ENG-PUDSP21010-R3-CDs-Channel.pdf Markup Summary

Comments remain cursory due to the need for the design report, additional grading, complete details and how this ties in to the ultimate subdivision design.

Engineering Review
 04/20/2022 4:17:19 PM
 dsdrice
 JctRisks@engr.com
 (714) 933-7877
 EPC Planning & Community
 Development Department

GRANDVIEW METRO DISTRICT
 GENERAL NOTES

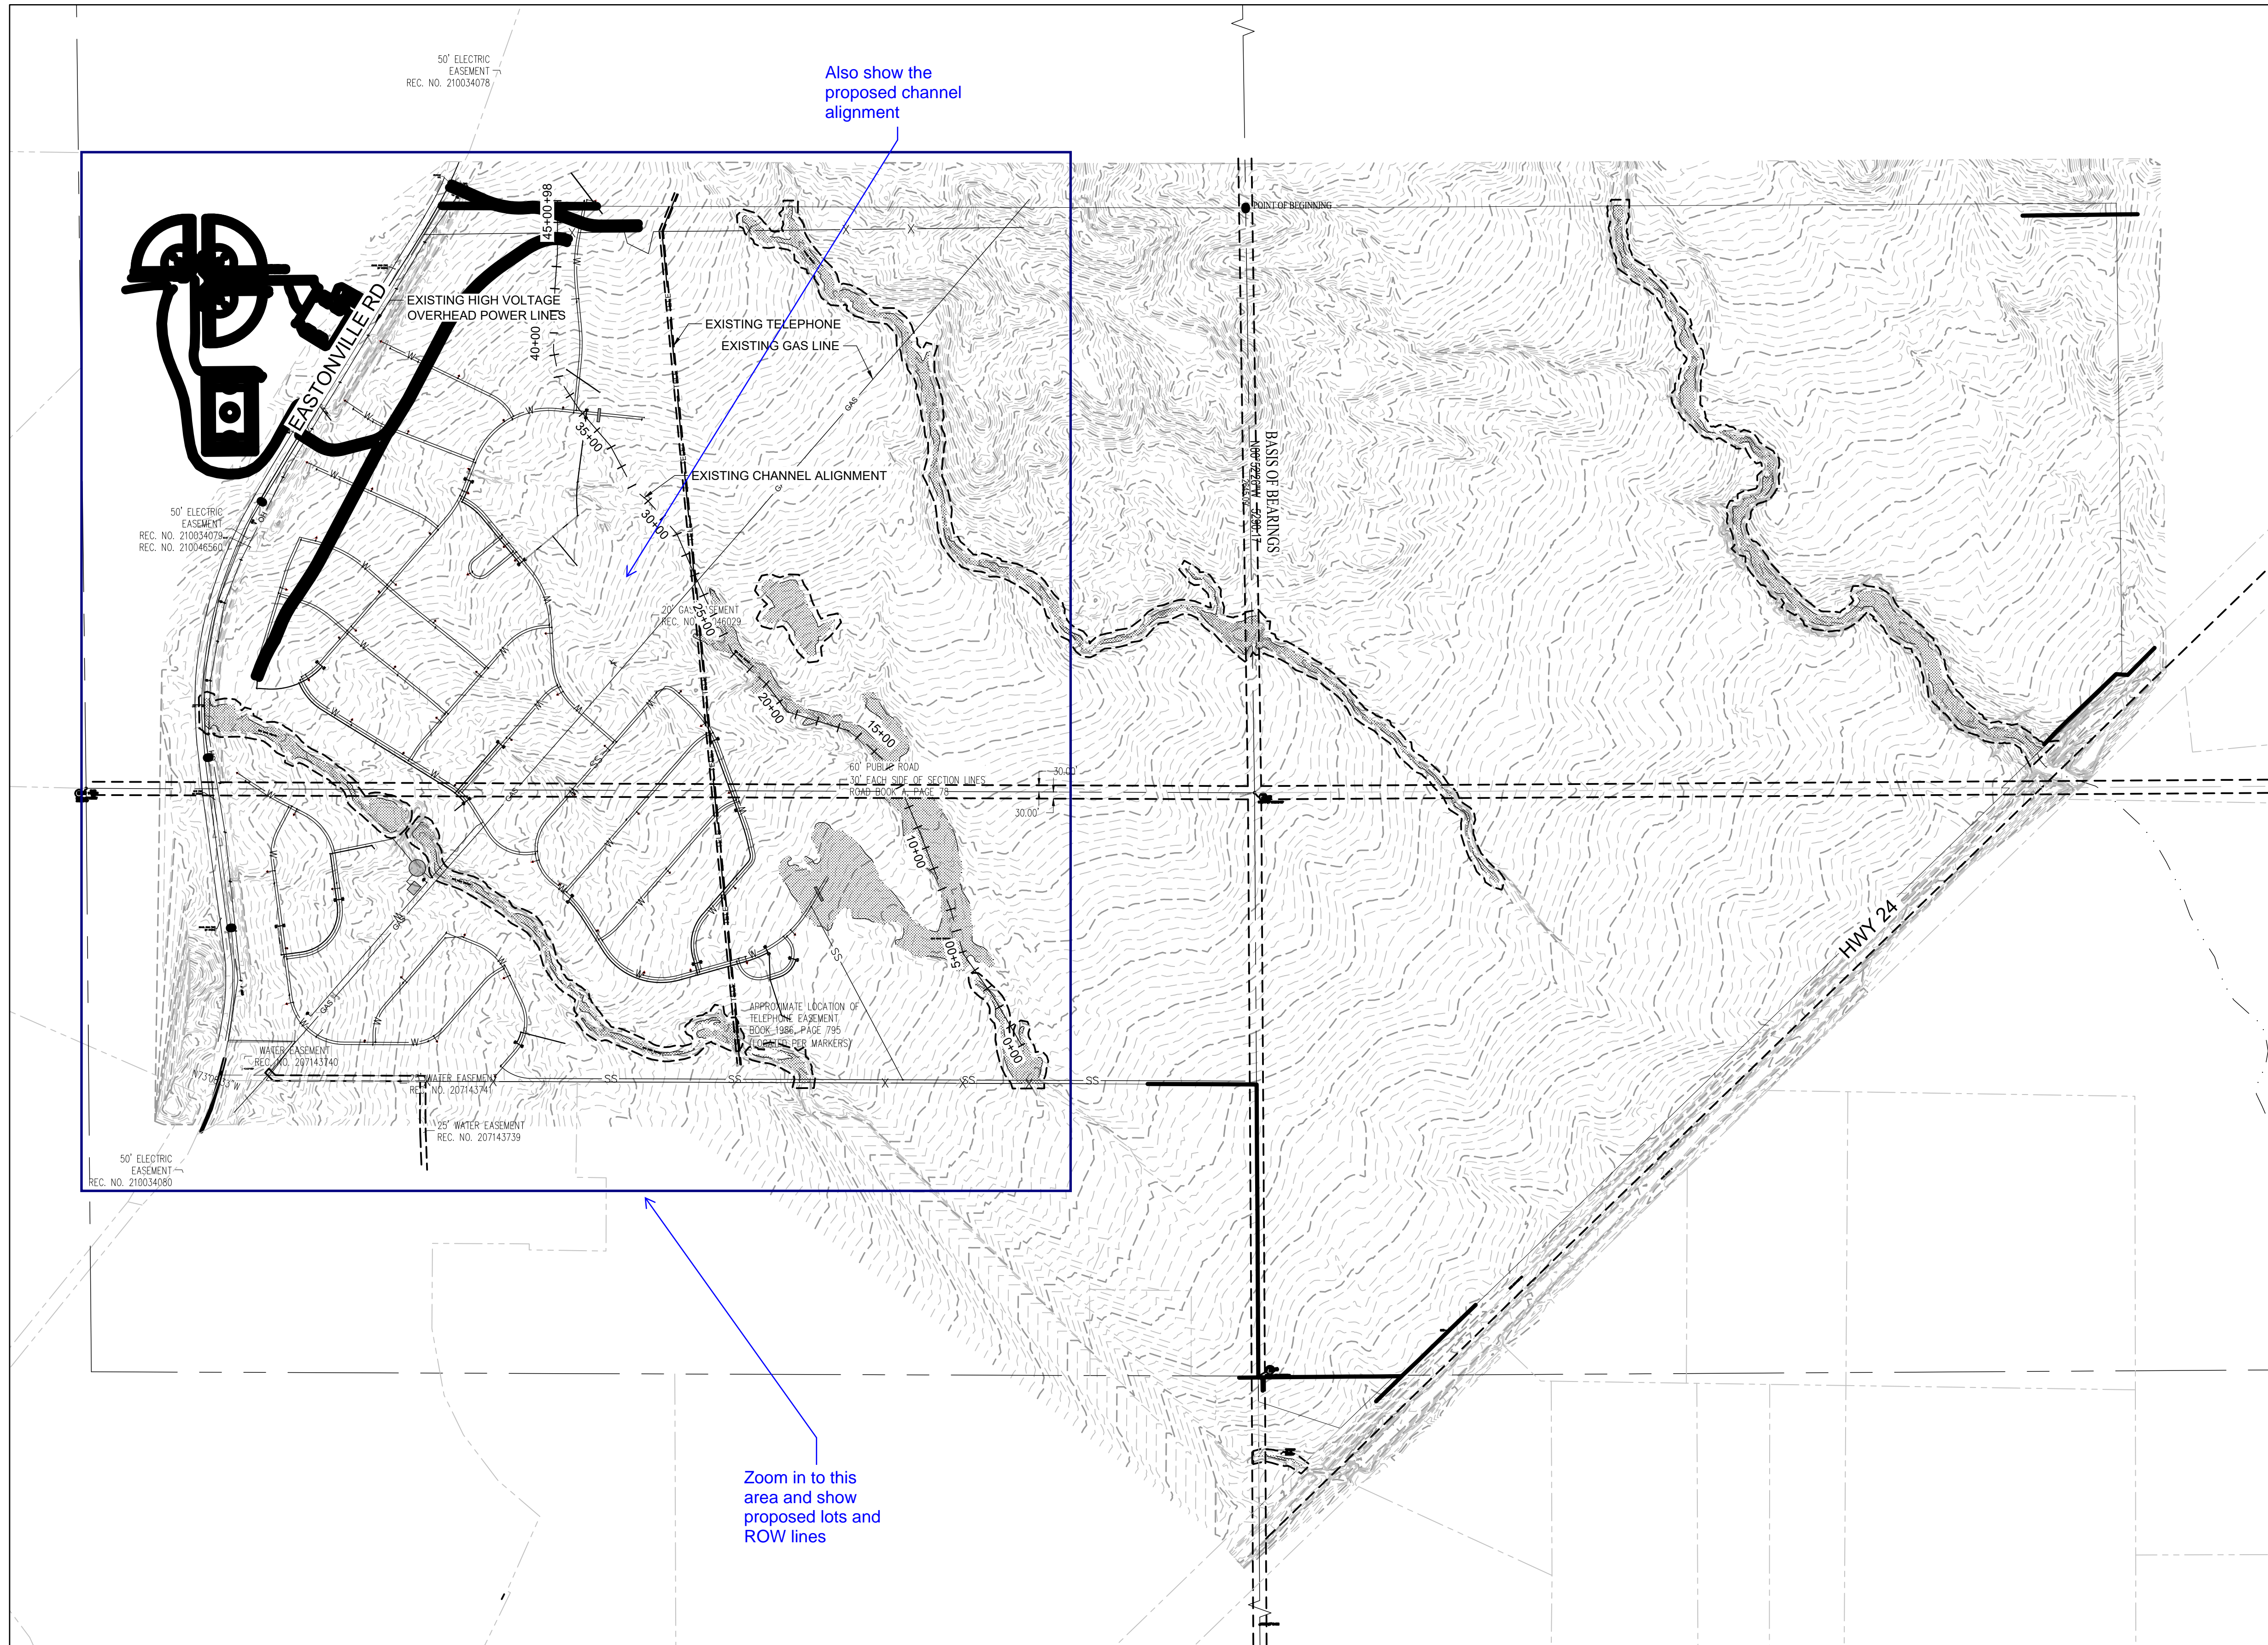
:SIGN PARAMETERS provide the values

provide the values

ECM 10.5.4: A minimum conveyance capacity of down to 10% of the 100 year storm event may be allowed if overbank conditions and scour velocities permit or only as otherwise approved by the City/County Engineer.

not less than 8 ft for channels conveying at least 400 cfs

1.2 lb/sf
70% of 2 year, 10.5 cfs
C4
2.7-31.65 (x=5.26)

0.8
1.2 lb/sf
70% of 2-year discharge of 10% of 100-yr discharge, whichever is greater
Per Table 8-2

2
10-yr storm, to be
use this

3.8 ft

SHEET NO.
UP1 03

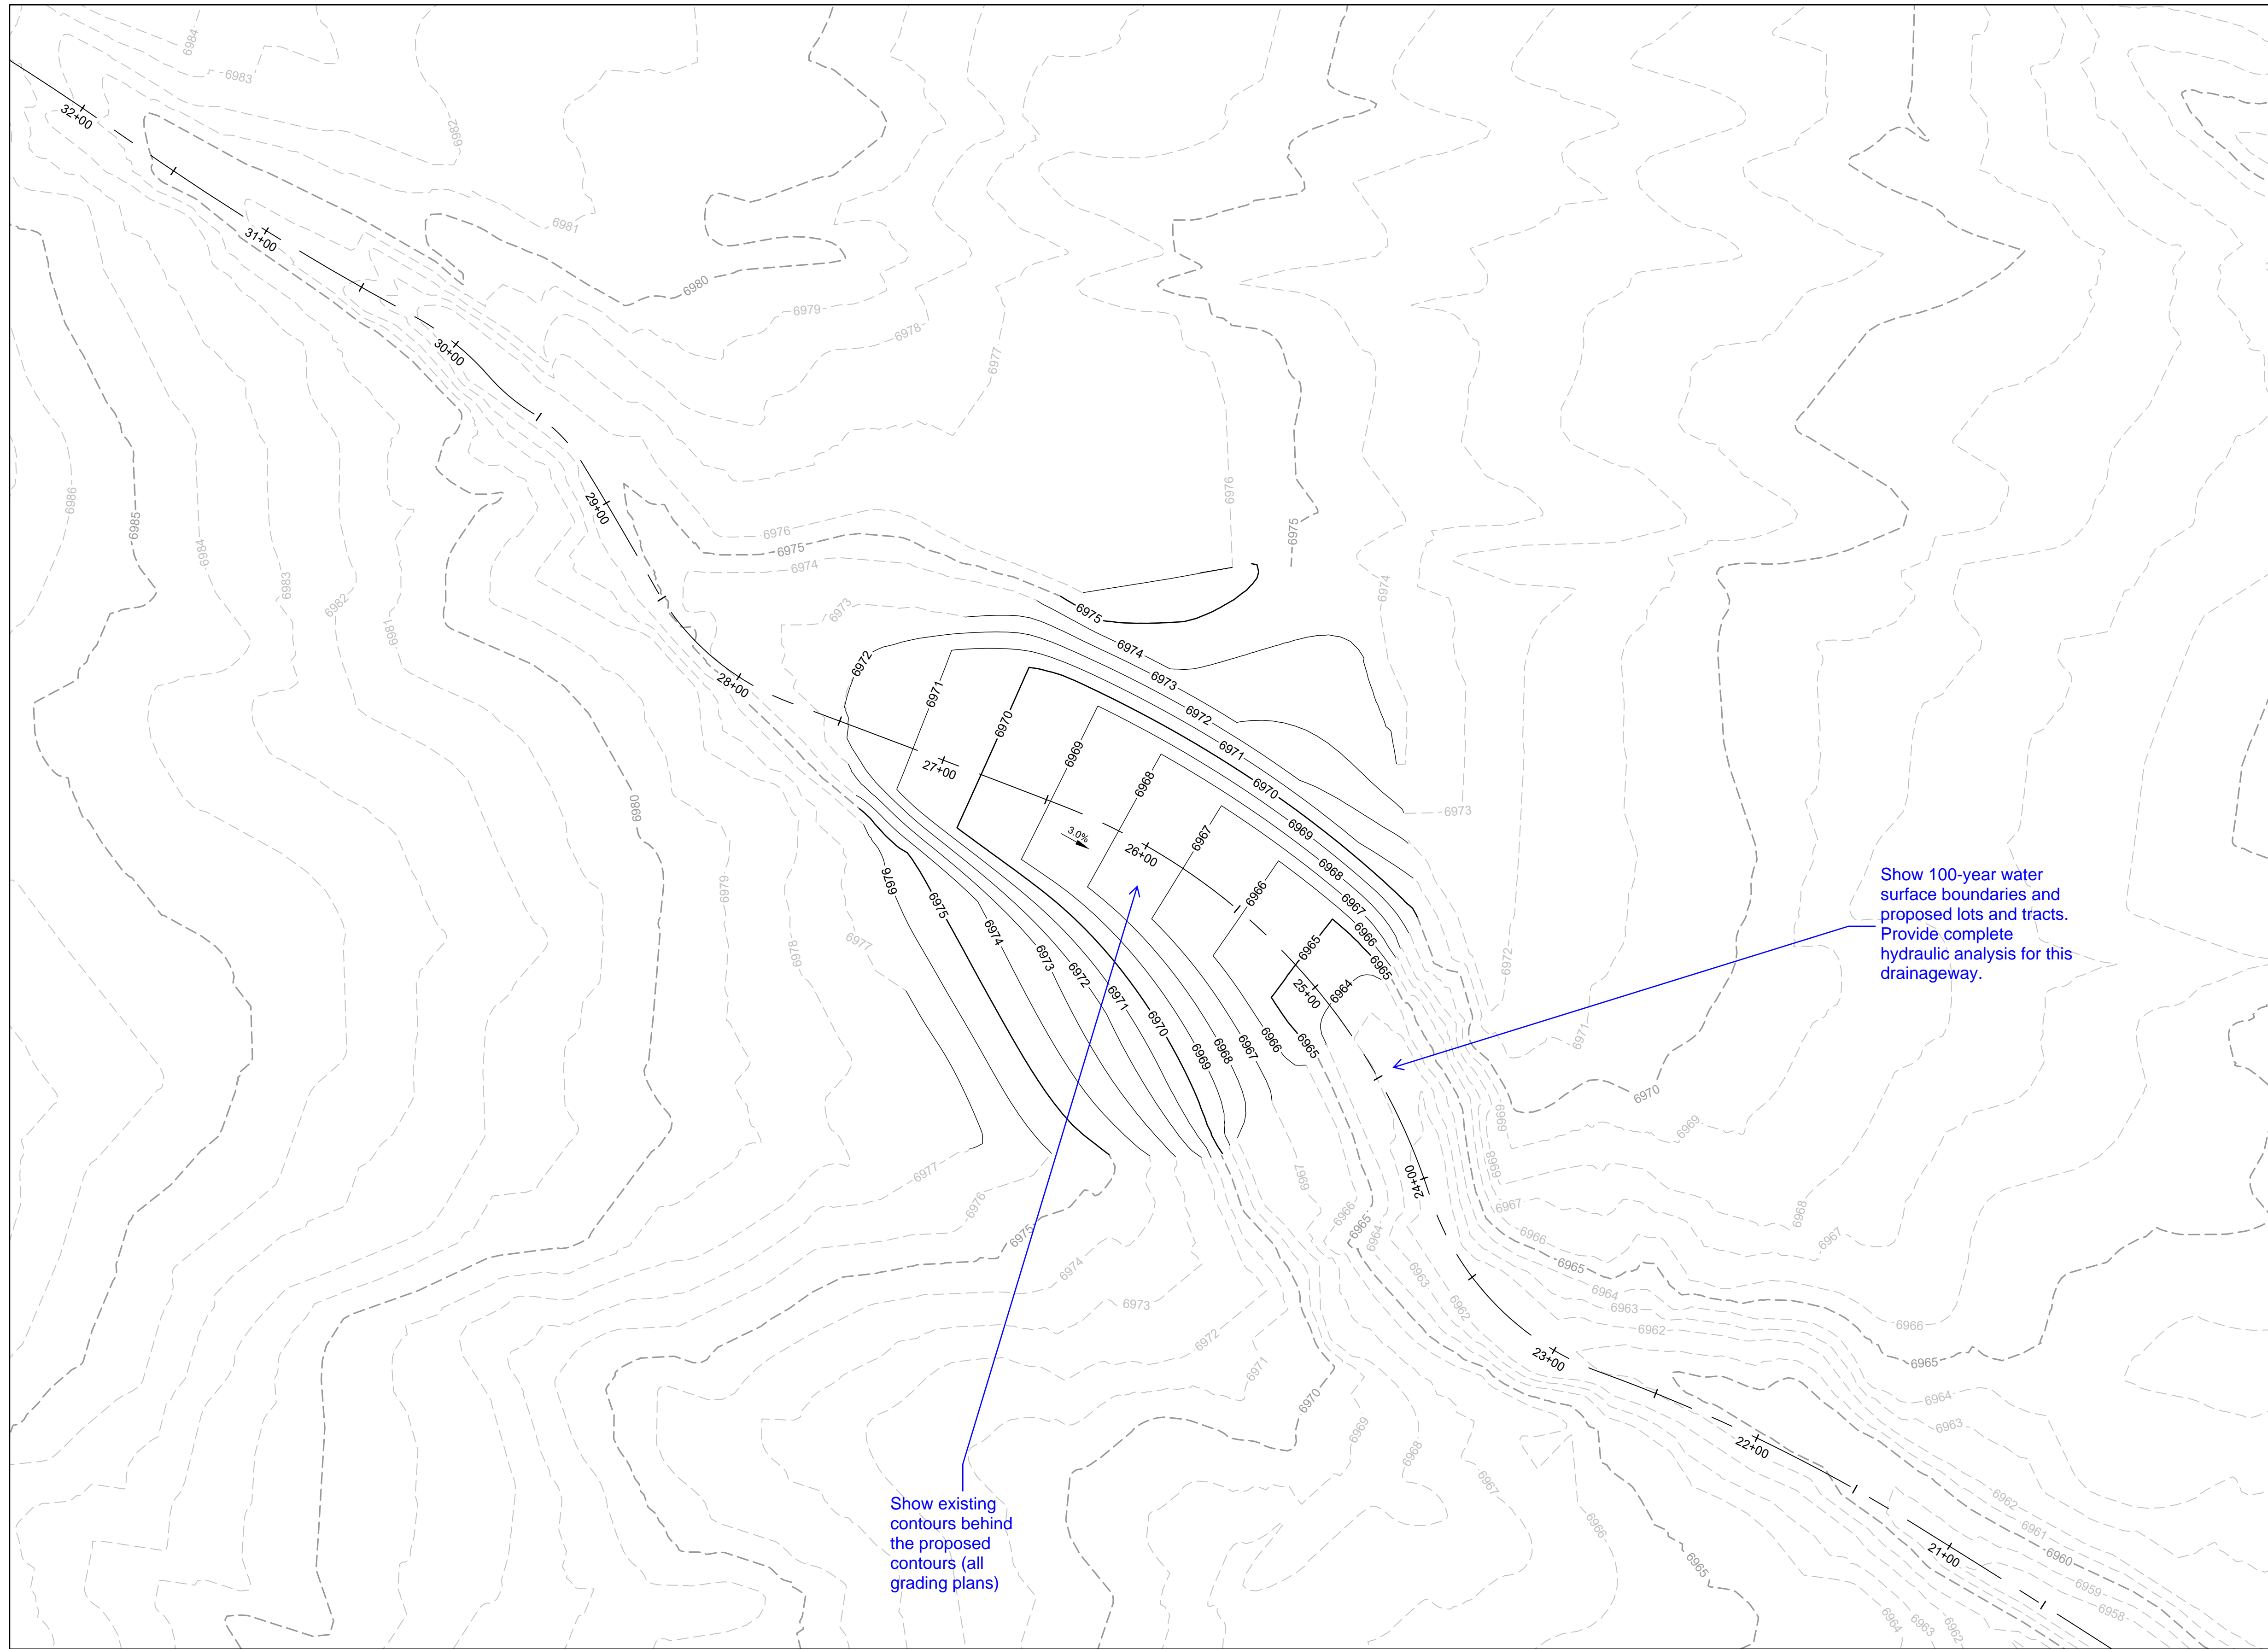
Subject: Callout Show proposed lots and ROW lines
Page Index: 3
Date: 4/20/2022 4:10:29 PM
Author: dsdrice
Color: ■
Layer:
Space:
Page Label: [3] 03 OVERALL UTILITY PLAN

SHEET NO.
GR1 04

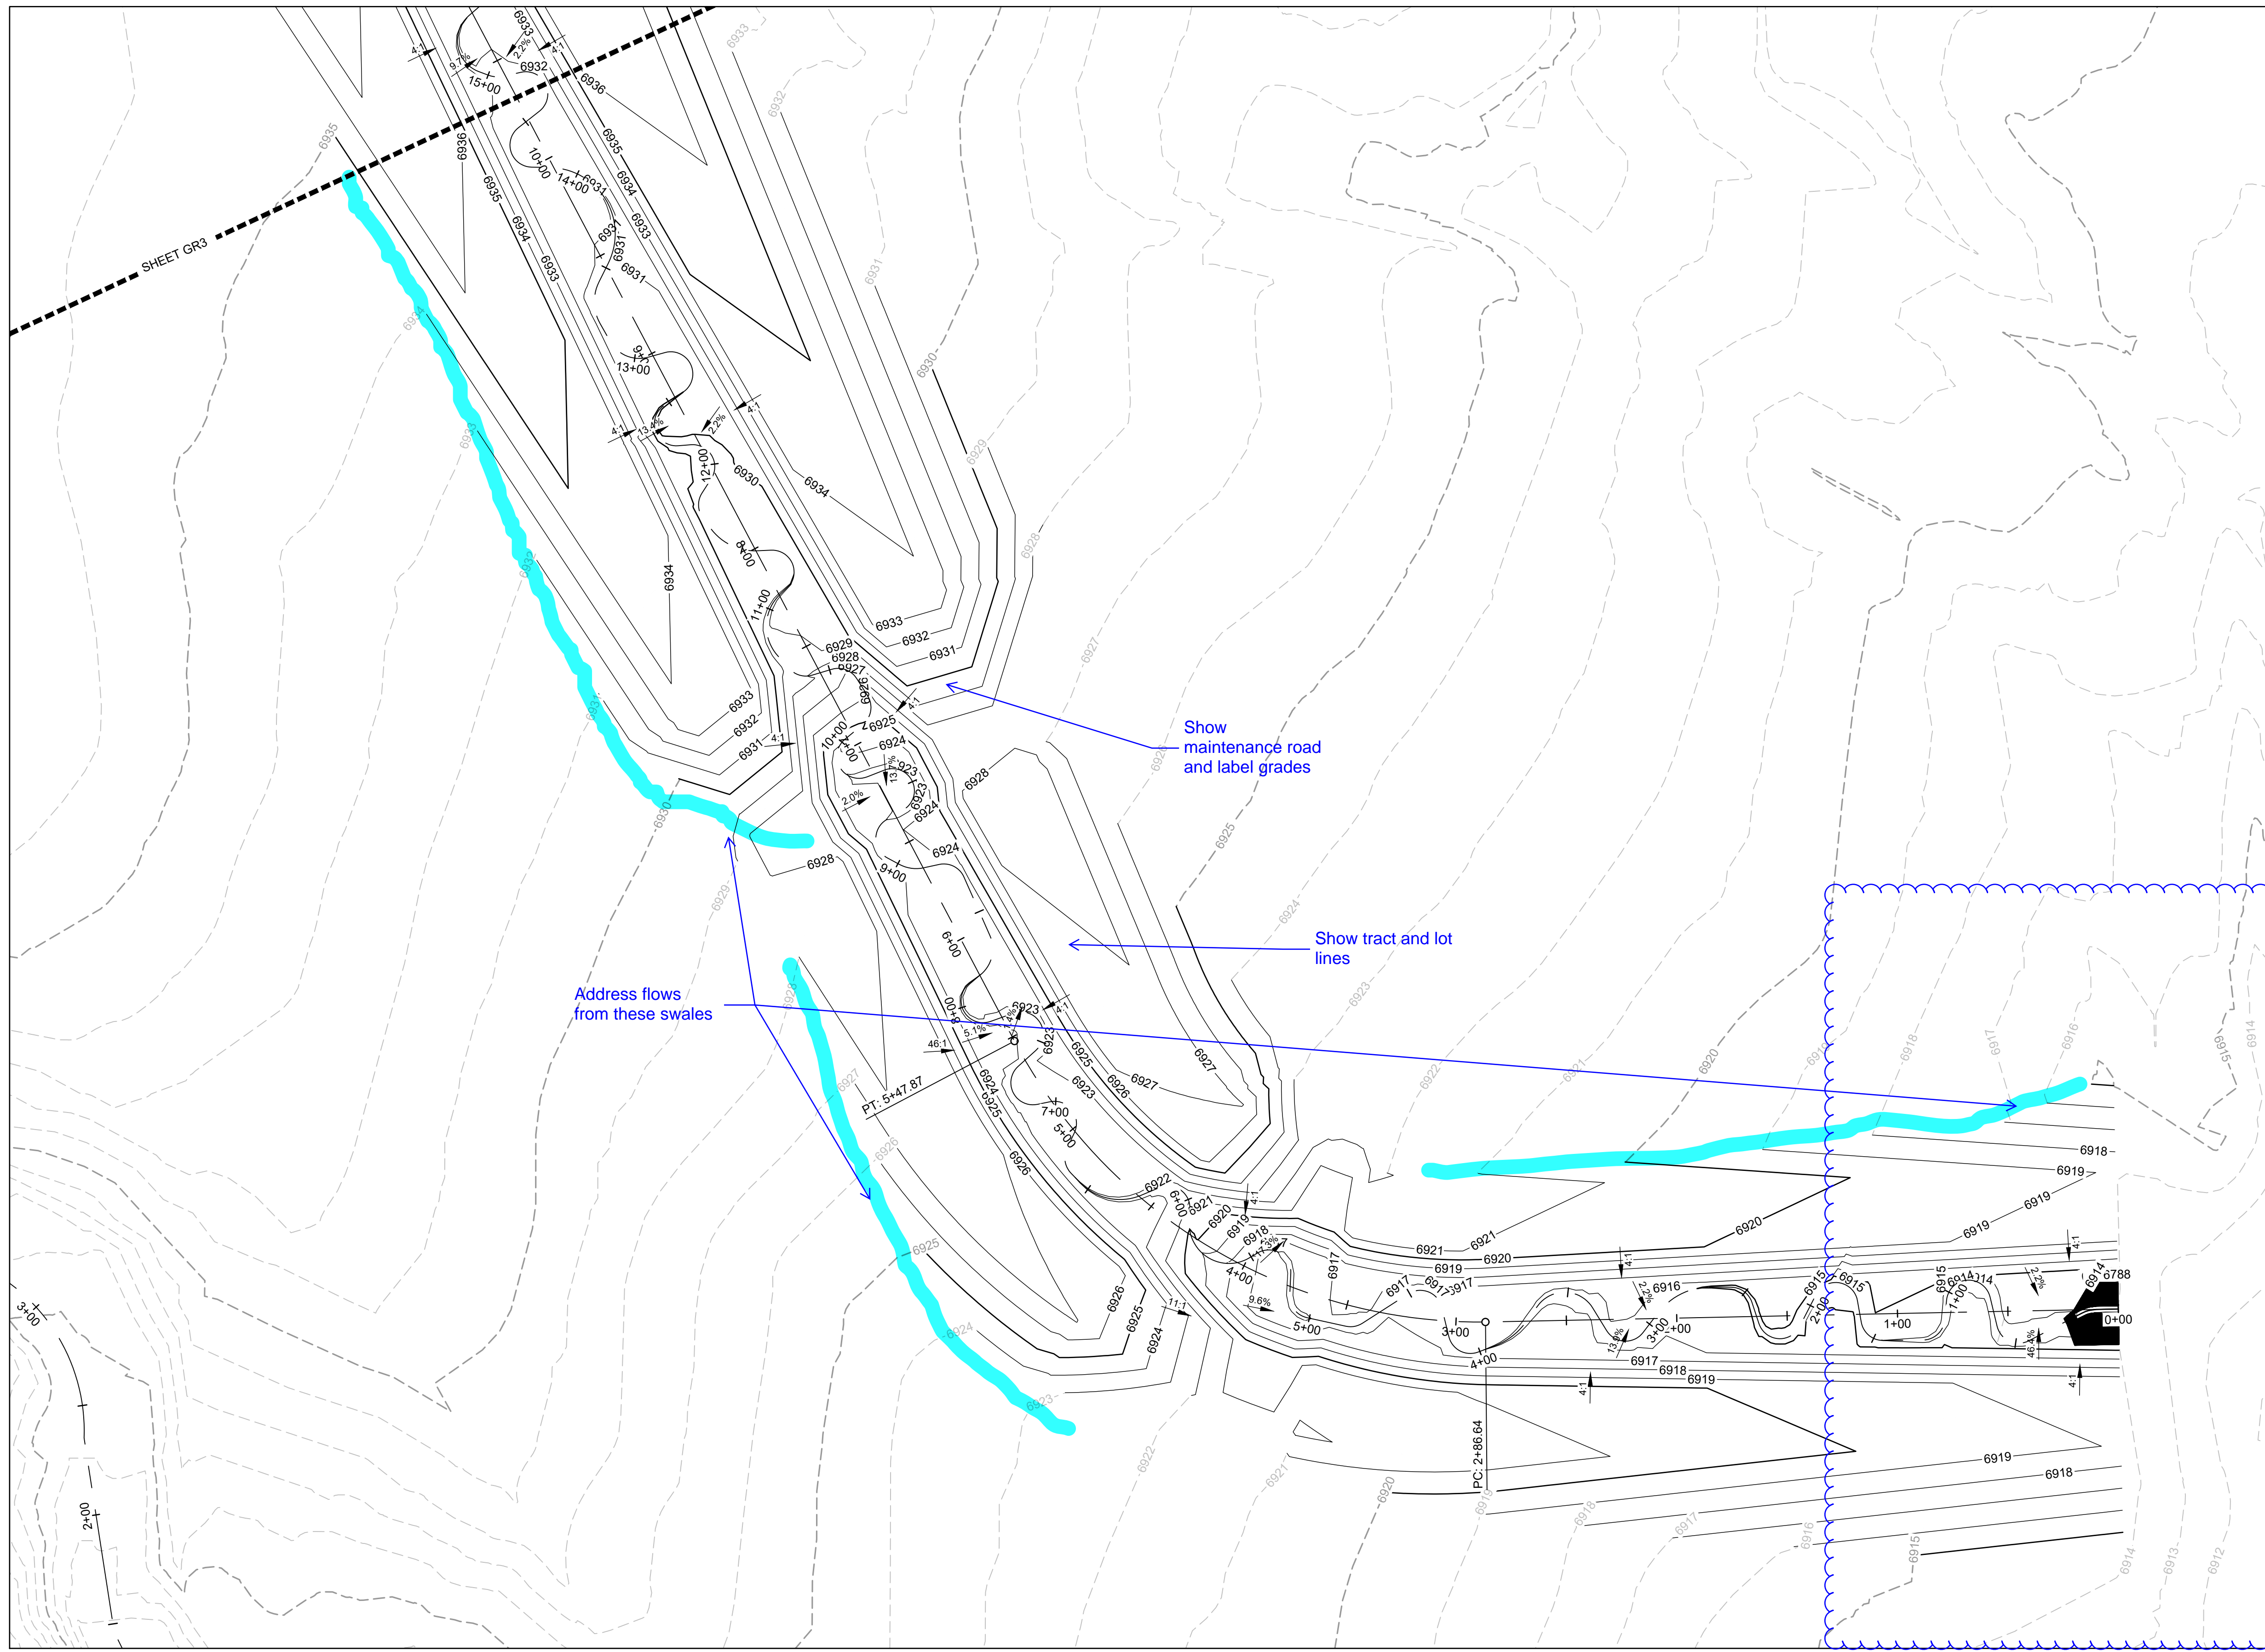
Label roads, lots and tracts

Show trails/maintenance access roads
